May 28, 2020

Subject: **Review of Structural and Civil Drawings**
Proposed Ne Shinde Residence
4207 West Mercer Way
Mercer Island, Washington

Reference: *Geotechnical Engineering Study*; Geotech Consultants; May 11, 2016.

DETENTION
TANK DETAILS

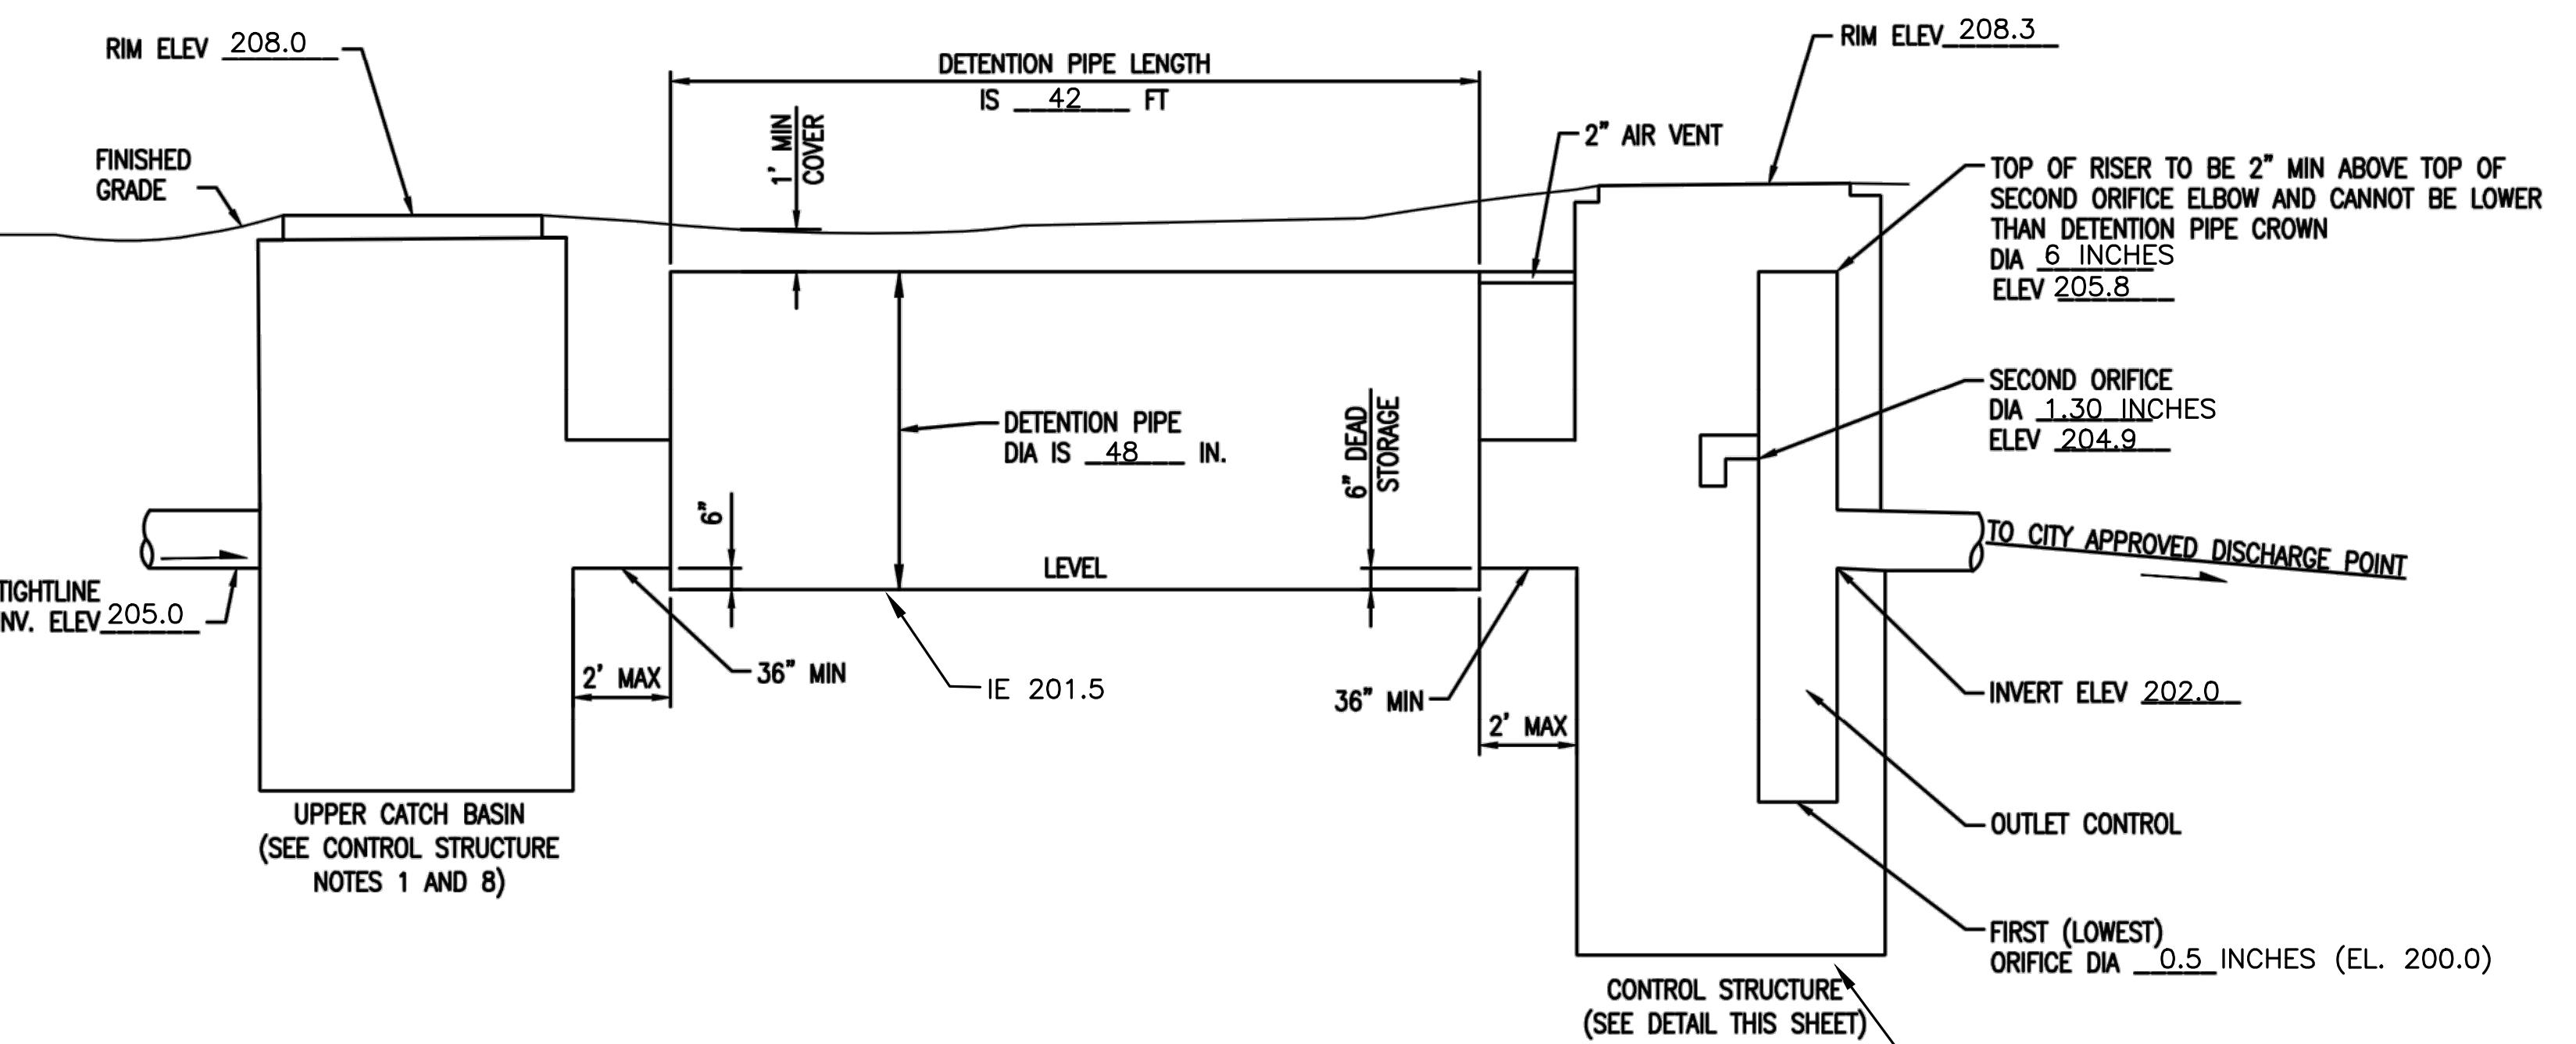
A large detention tank must be installed between the new house and the north property line. It would not be appropriate to install the detention tank closer to the steep slope, as the detention tanks have been known to leak and this would present a risk to the slope. The HDPE outlet for the detention tank will be a flow spreader located at the base of the slope, alongside the watercourse. This is an appropriate discharge point, as the surface runoff from the site currently flows to this point.
